Natural England's key to RAG status	Risk
<p><b>Purple</b></p> <p>Note for Examiners and/or competent authority. May relate to DCO/DML.</p>	
<p><b>Red</b></p> <p>Natural England considers that unless these issues are resolved it will have to advise that (in relation to any one of them, and as appropriate) it is not possible to ascertain that the project will not affect the integrity of an SAC/SPA and/or comply fully with the Environmental Impact Assessment requirements and/or avoid significant adverse effect on landscape/seascape, unless the following are satisfactorily provided:</p> <ul style="list-style-type: none"> <li>new baseline data;</li> <li>significant design changes; and/or</li> <li>significant mitigation;</li> </ul> <p>Natural England feels that issues given Red status are so complex, or require the provision of so much outstanding information, that they are unlikely to be resolved during examination, and respectfully suggests that they be addressed beforehand.</p>

No.	Natural England's Relevant Representation - Appendix A - Generic Issues	RAG status Rel and WR Rep	Consultation, actions, progression	RAG status D1	Consultation, actions, progression	RAG status D2
<b>Append

Plate A1- 3 Mitigation measures proposed for the Habitat Mitigation Area

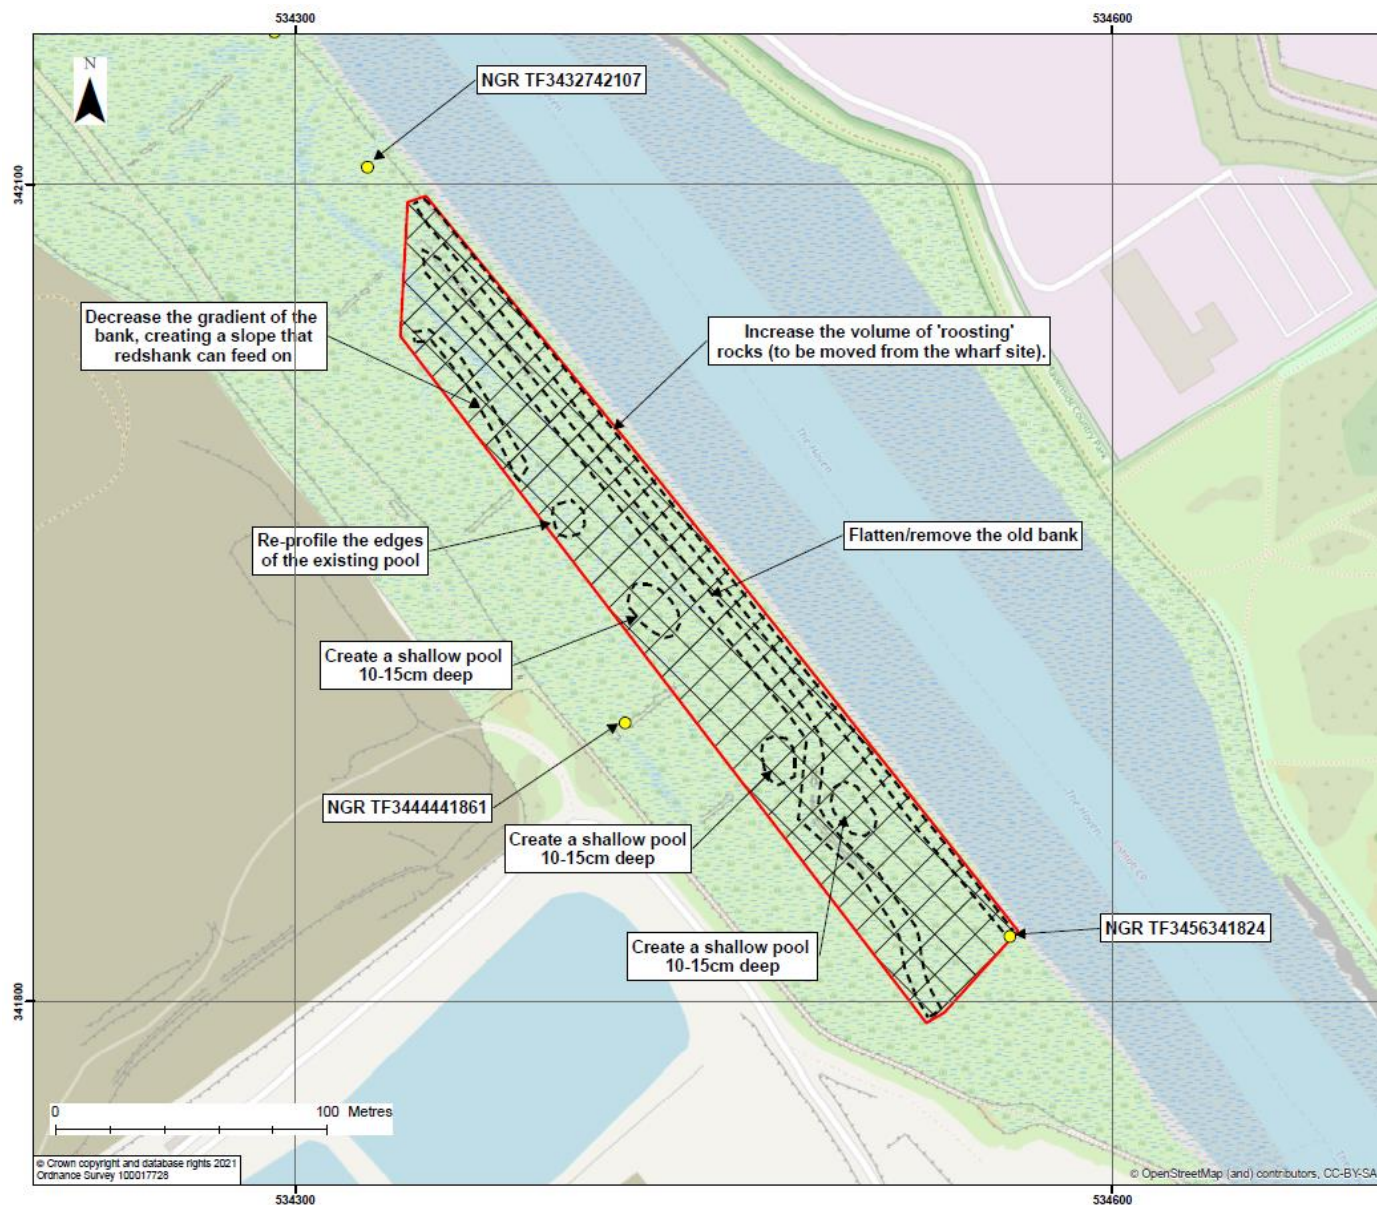
No.	Natural England's Relevant Representation - Appendix C - Intertidal and Marine Ecology	RAG status Rel and WR Rep	Consultation, actions, progression	RAG status D1	Consultation, actions, progression	RAG status D2
4	Under the Habitat Mitigation Works within the Habitat Mitigation Area it mentions 4 shallow pools (max 15cm deep) created in the existing saltmarsh. Natural England is concerned that without maintenance these will quickly silt up. Therefore, we query what ongoing management will be needed to maintain these pools? Is the intention for these pools/ scrapes to remain unvegetated? Area of the 4 pools? Will the scrapes/ pools result in direct loss of further saltmarsh vegetation? Has this been calculated? this information is vital to assess the benefits of the proposed new area.		Please see issue 22b in the Offshore Ornithology section.		Please see issue 22b in the Offshore Ornithology section.
